From: [REDACTED]
Sent: 06 September 2026 13:48
To: Planning
Subject: Application No 3/2026/0616

I am writing in regards to Planning Application Number: 3/2026/0616.

Front Elevation with Fence Height

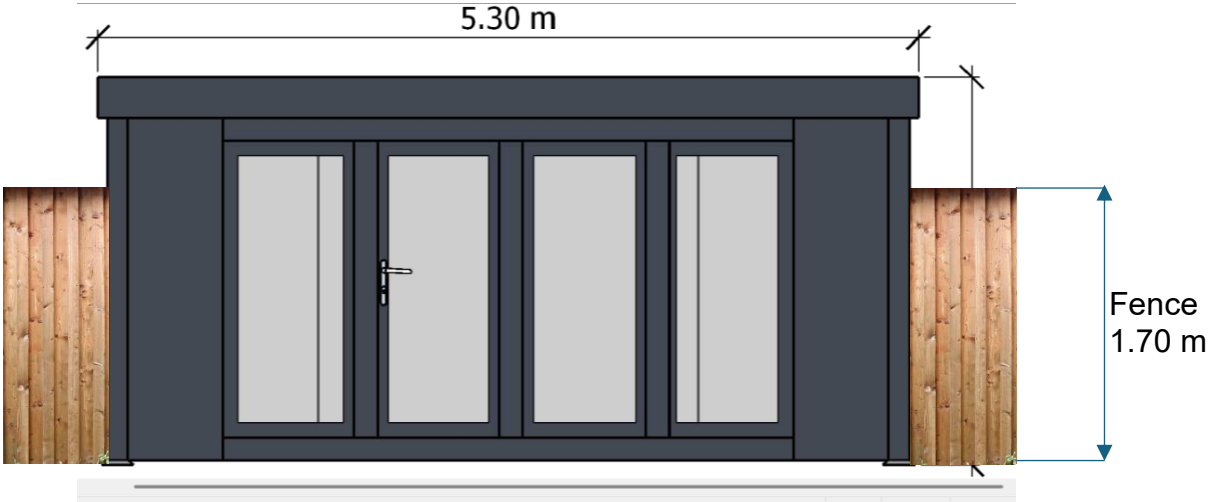
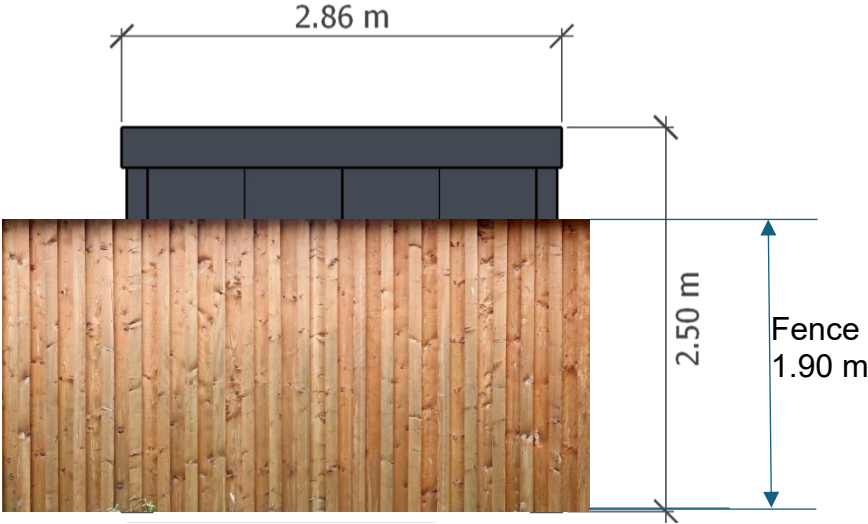
The only comment I have in regards to this application is, I will have no issue with this as long as this single storey studio building to the rear does NOT affect in anyway [REDACTED] as I have [REDACTED] and one [REDACTED] and I want in no way for any windows/etc to the rear of this single storey studio to [REDACTED].

If there is NO breach of privacy then I have no issue at all.
